Our Ref: FP/30/20/PL
Your Ref:

Town & Country Planning Act 1990 (as amended)
Town & Country Planning (Development Management Procedure) (England) Order 2015
Application for Planning Permission for Works or Extension to a Dwelling

Development Rear staircase
Location 9A Felpham Road Felpham

Reinstatement of rear staircase Site & Location Planning	Date January 2020	Scale 1:200 1:1250
--	----------------------	-----------------------

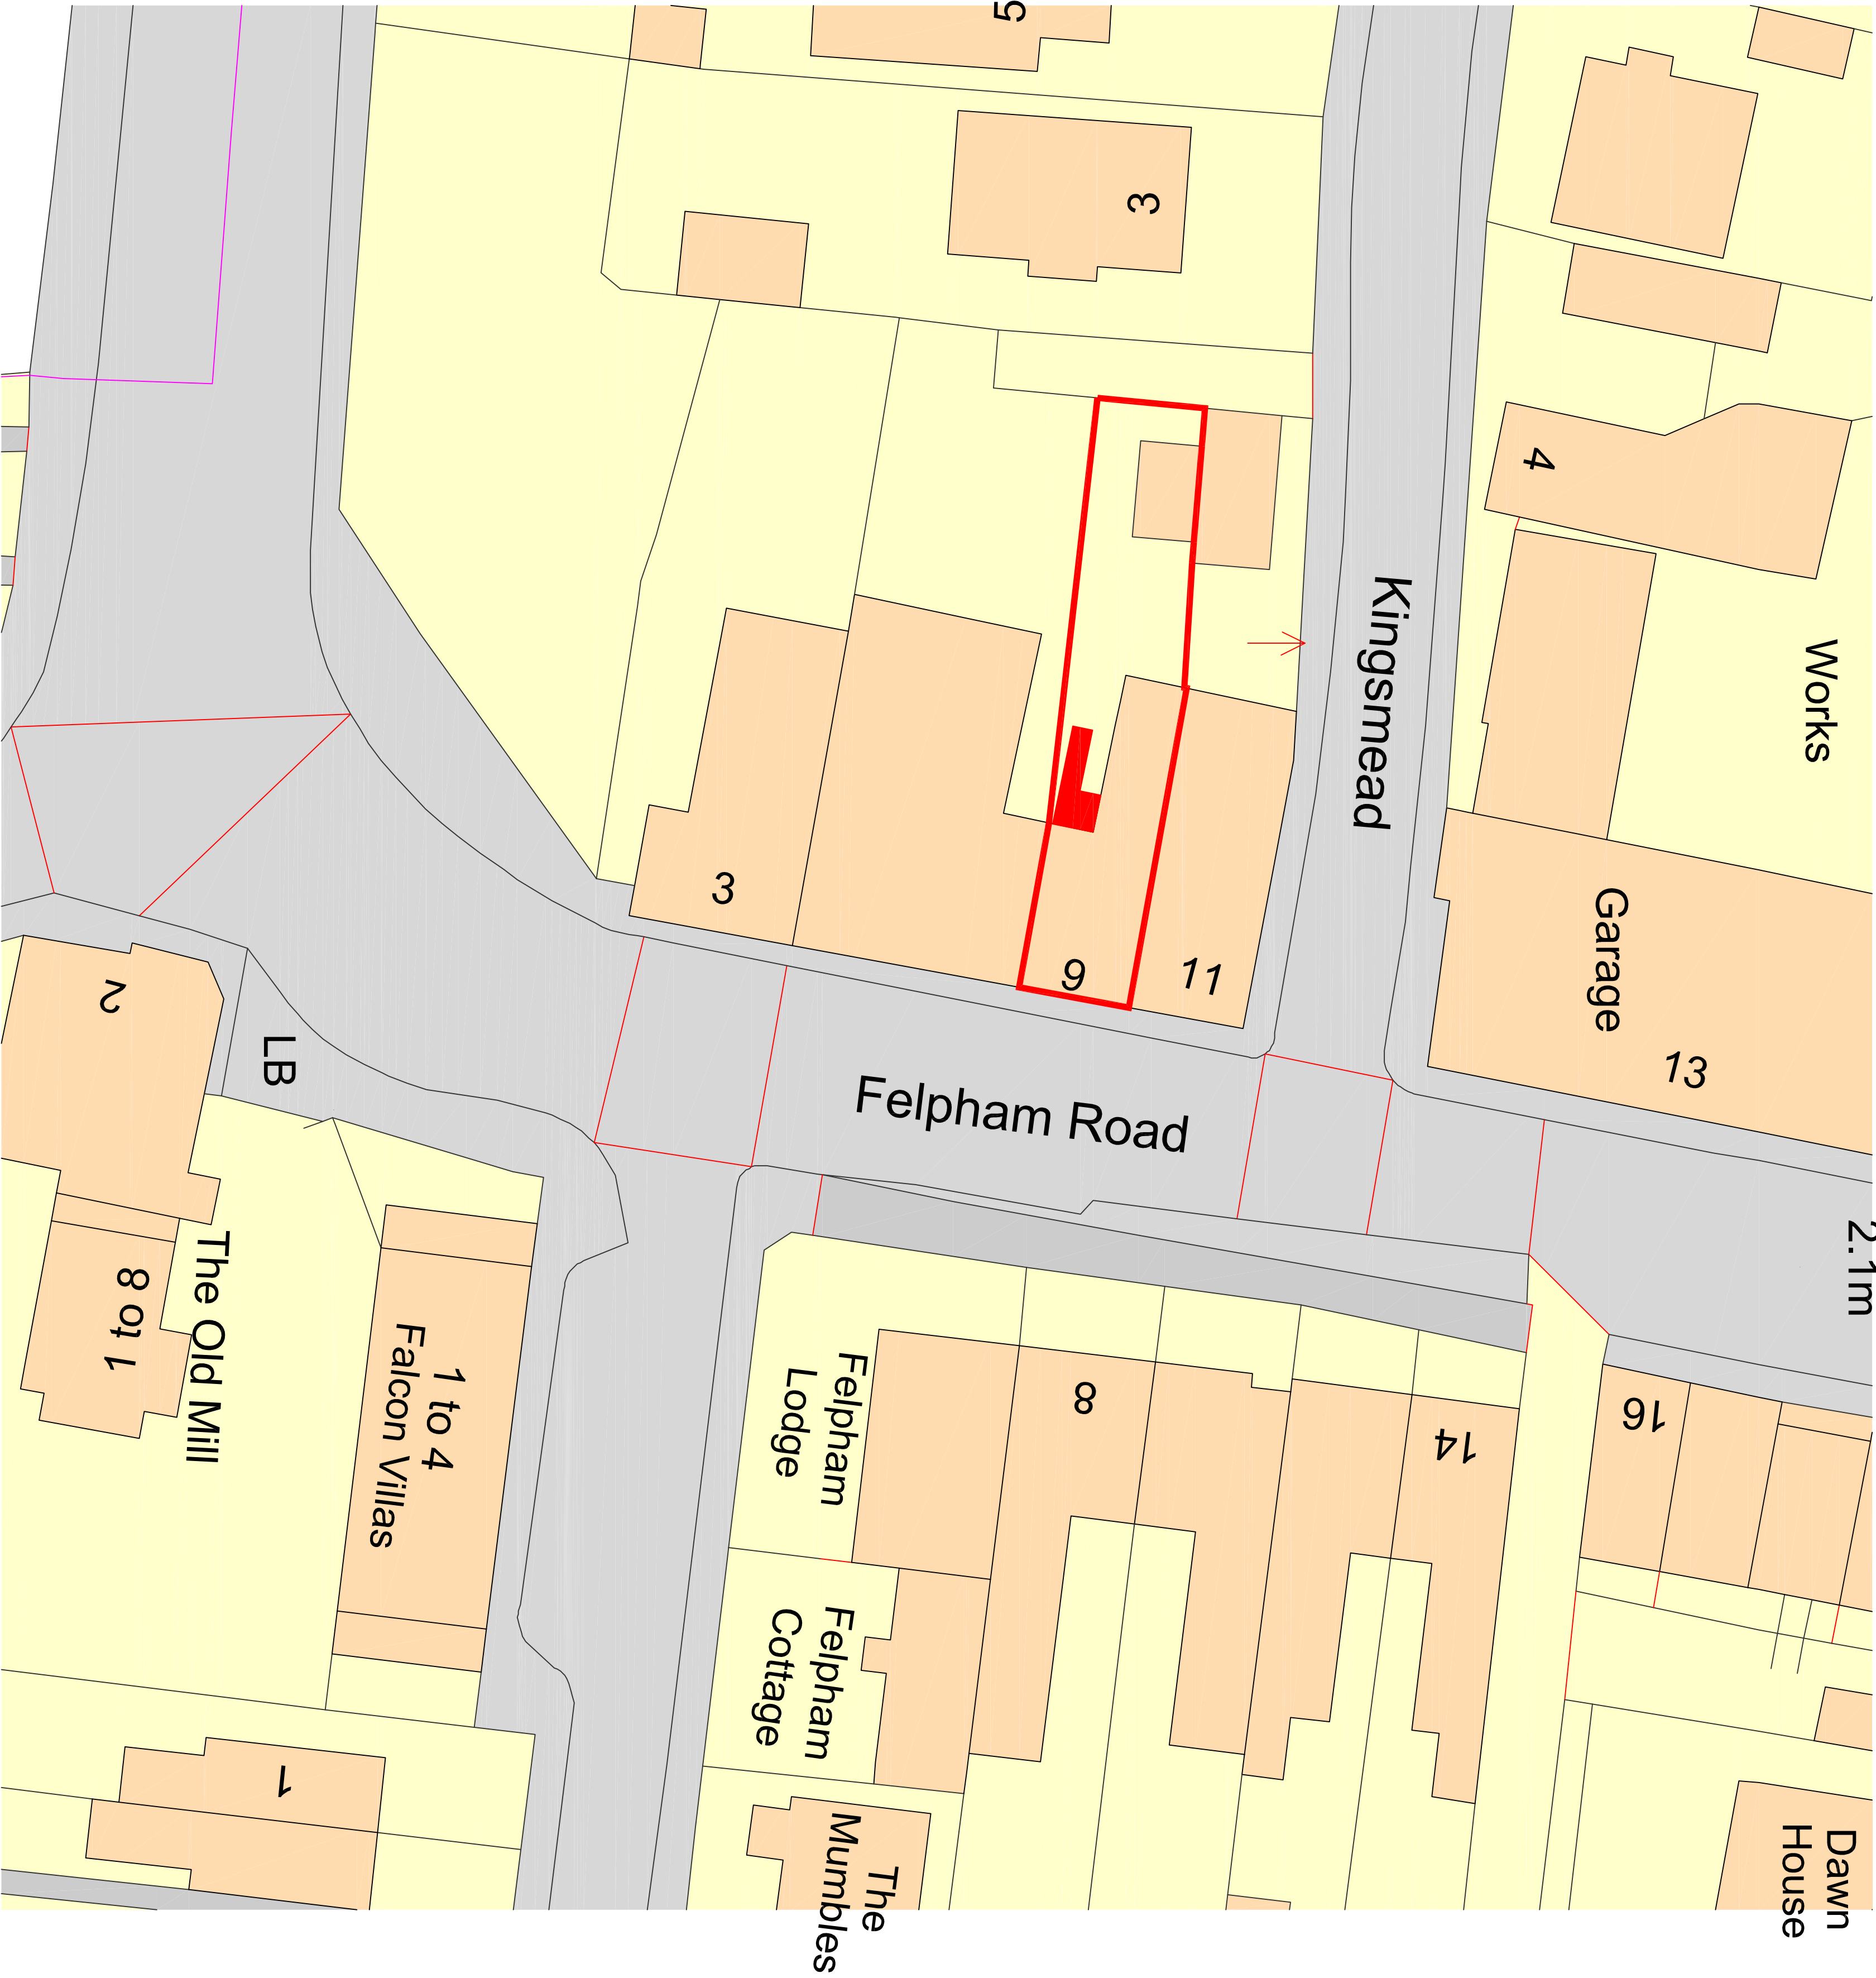
Location Plan Amend

Please provide two named roads.

Existing South Elevation

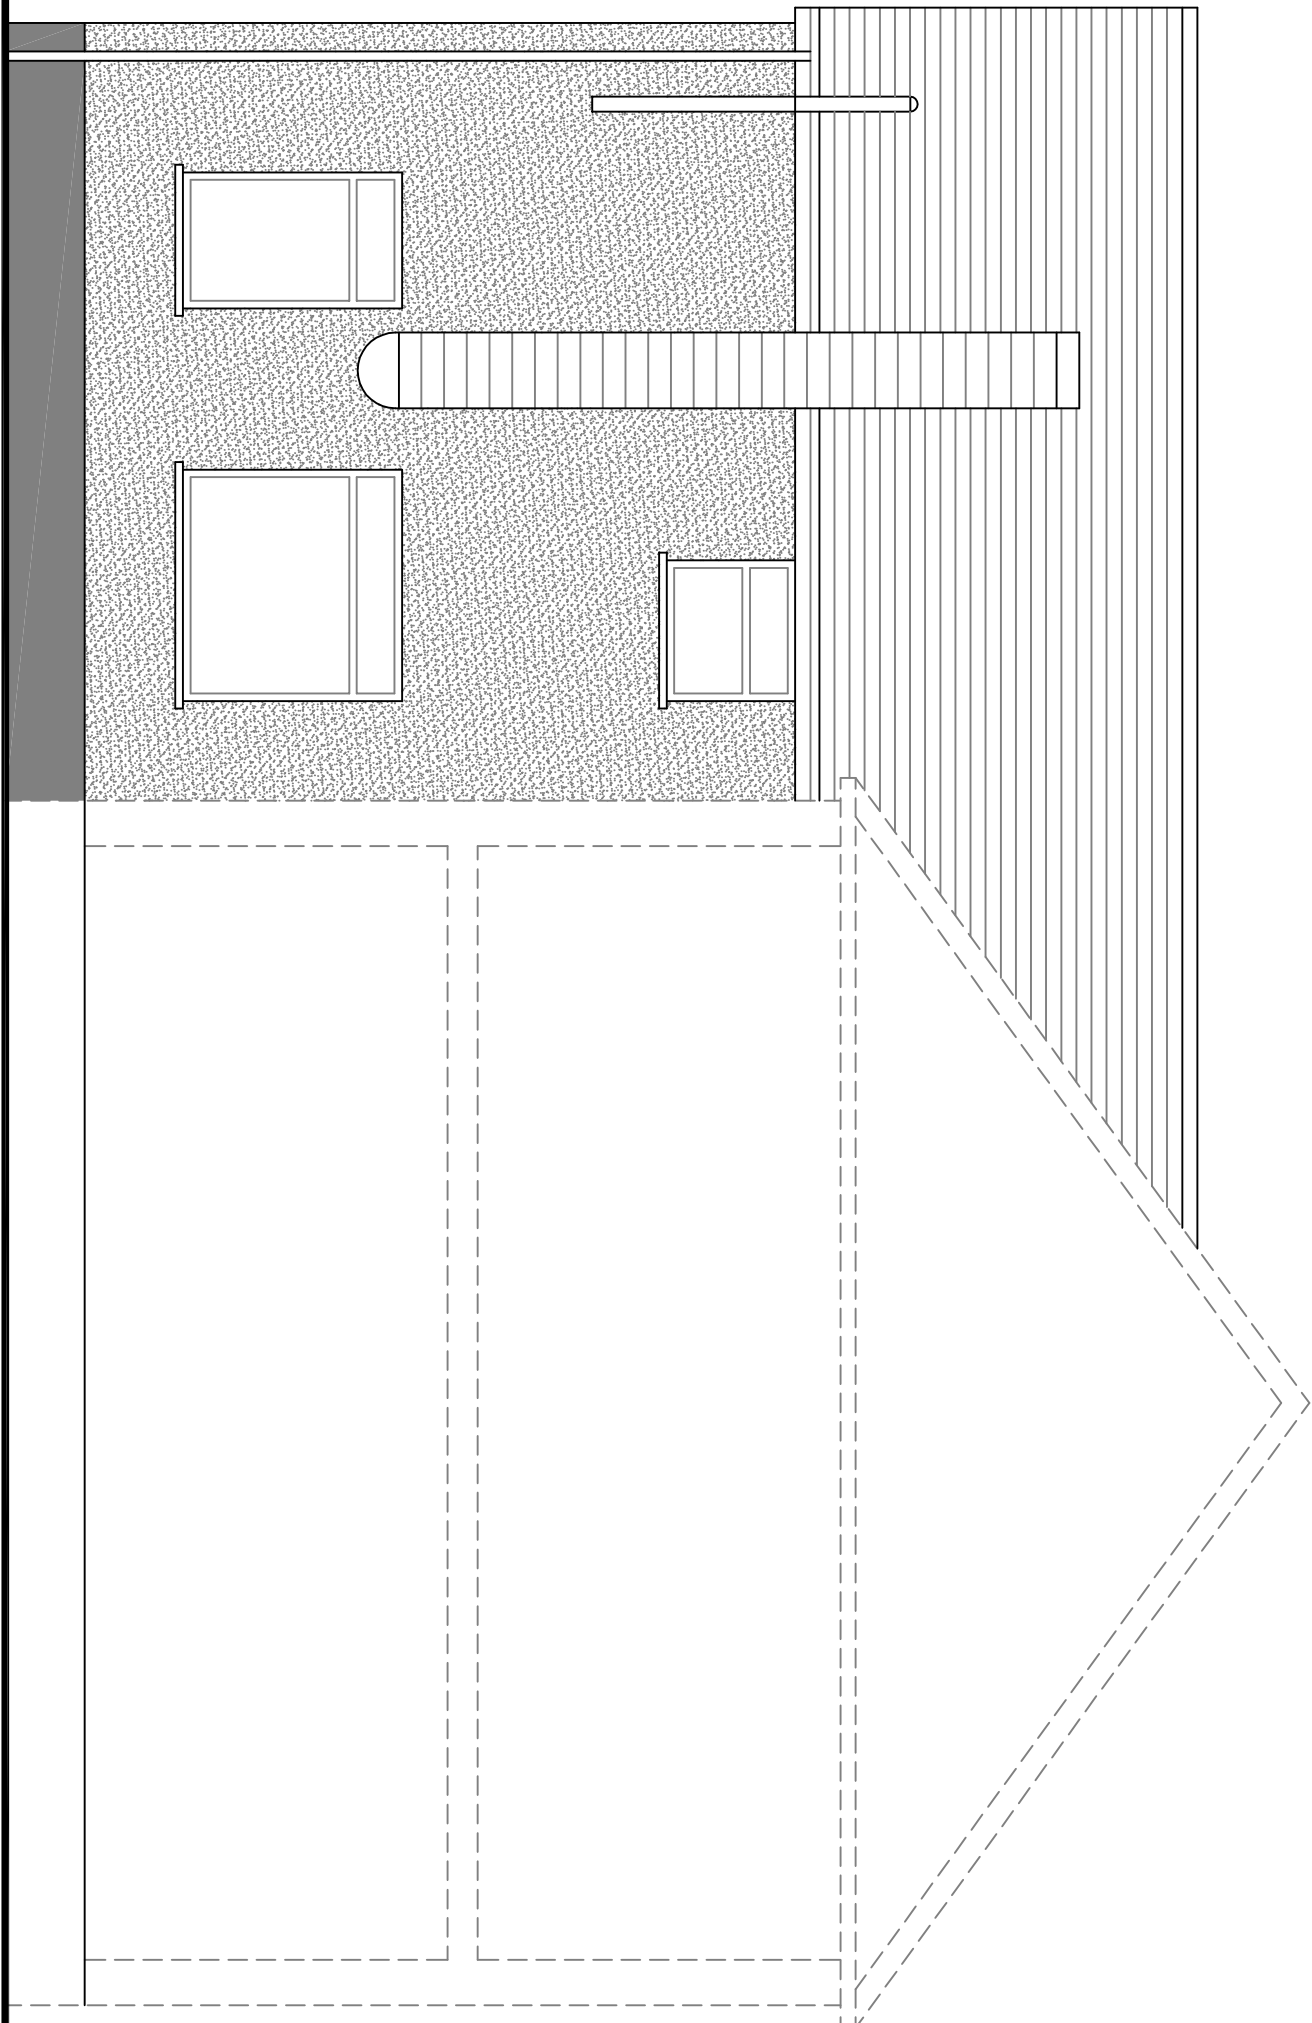
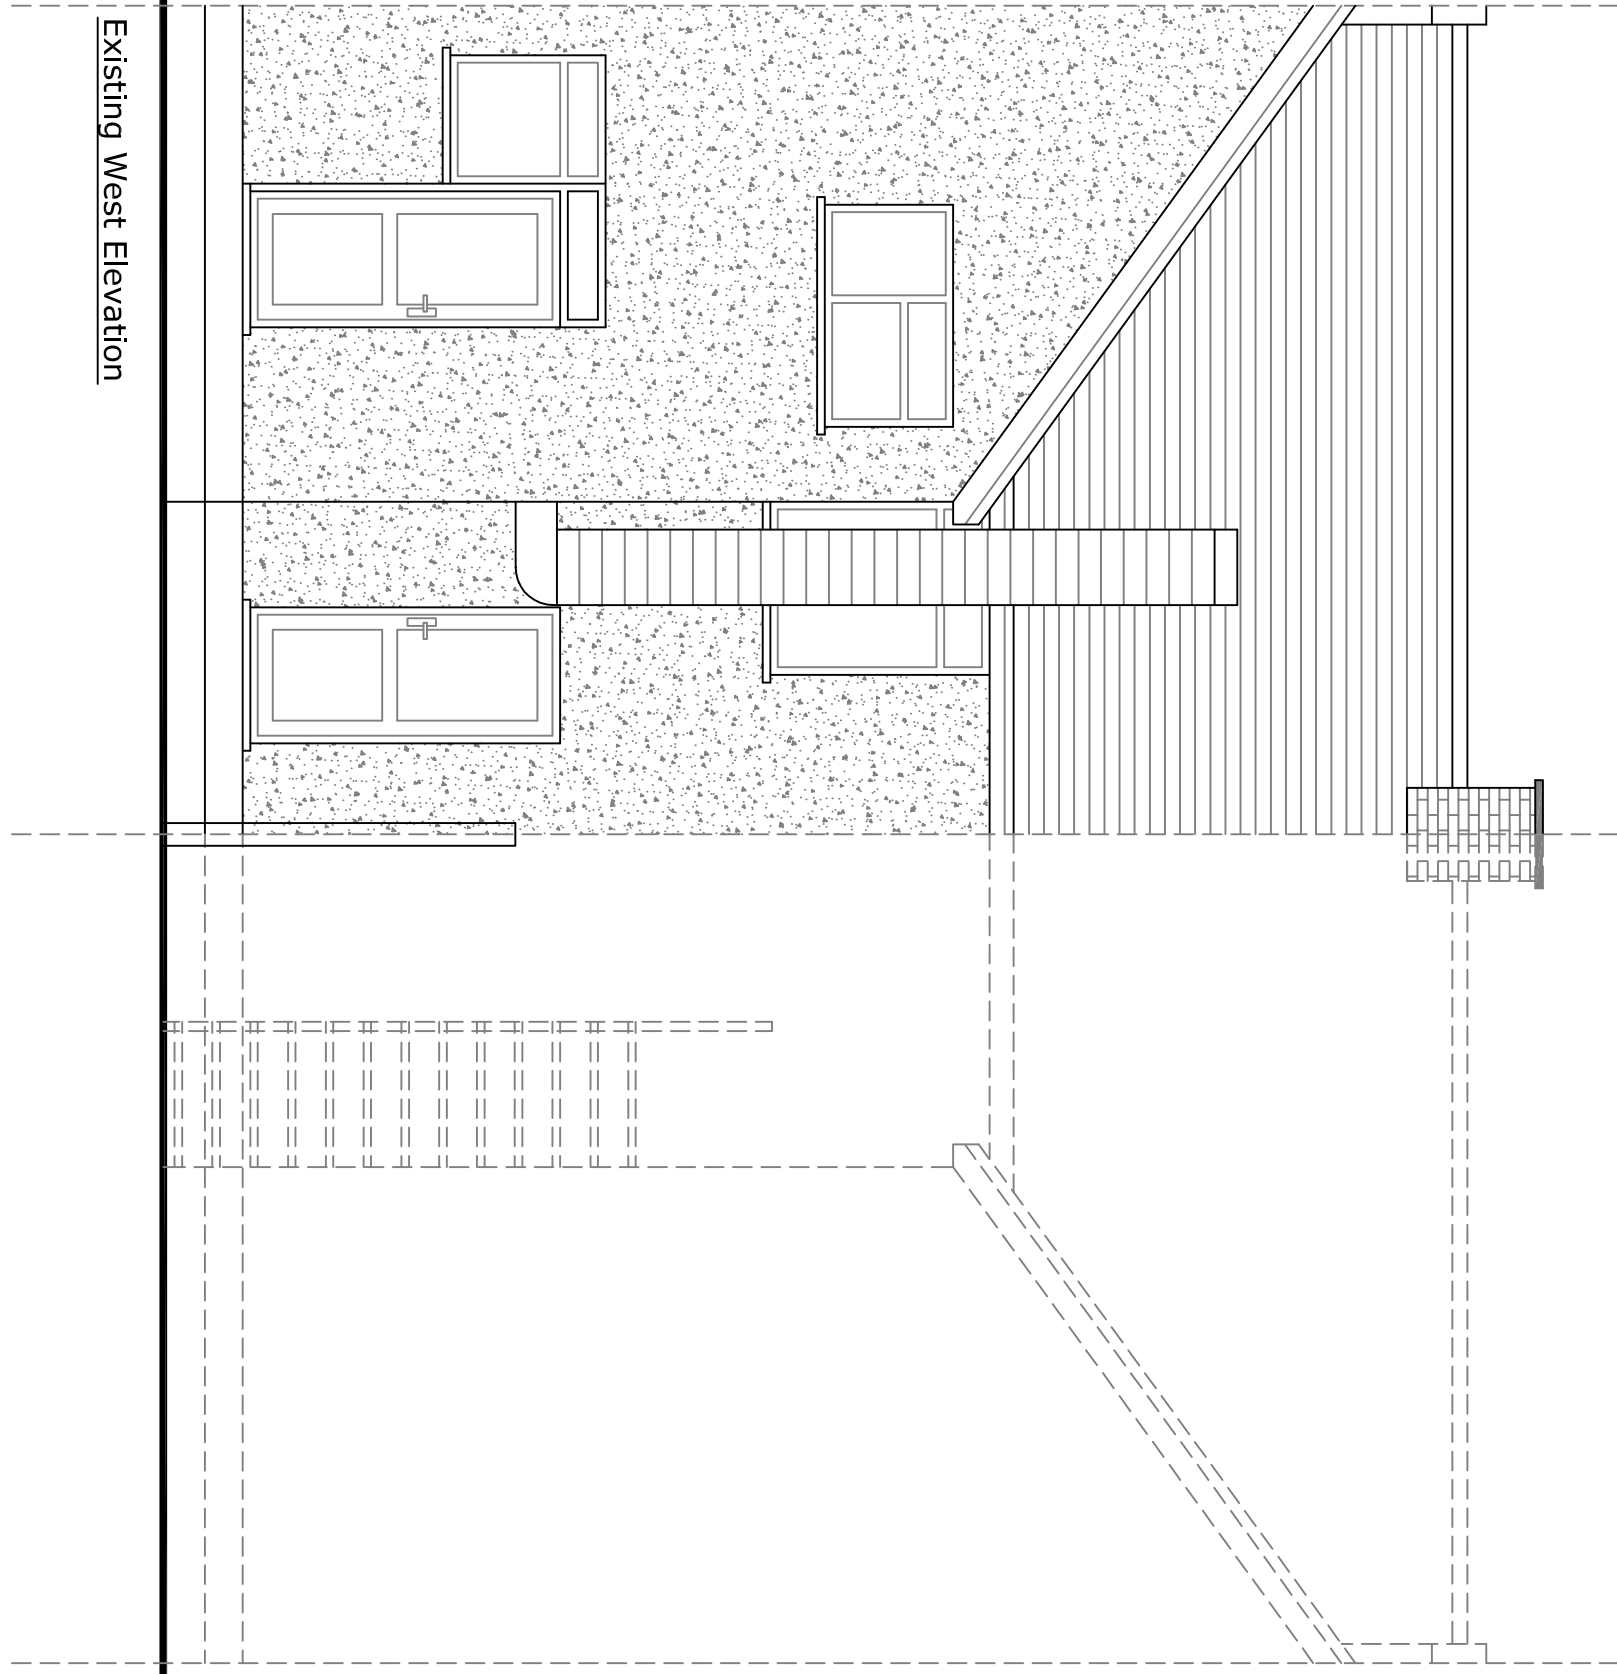
Two elevations have been labelled existing and proposed South elevations. Please amend accordingly.

Please provide existing and proposed west and north elevations.
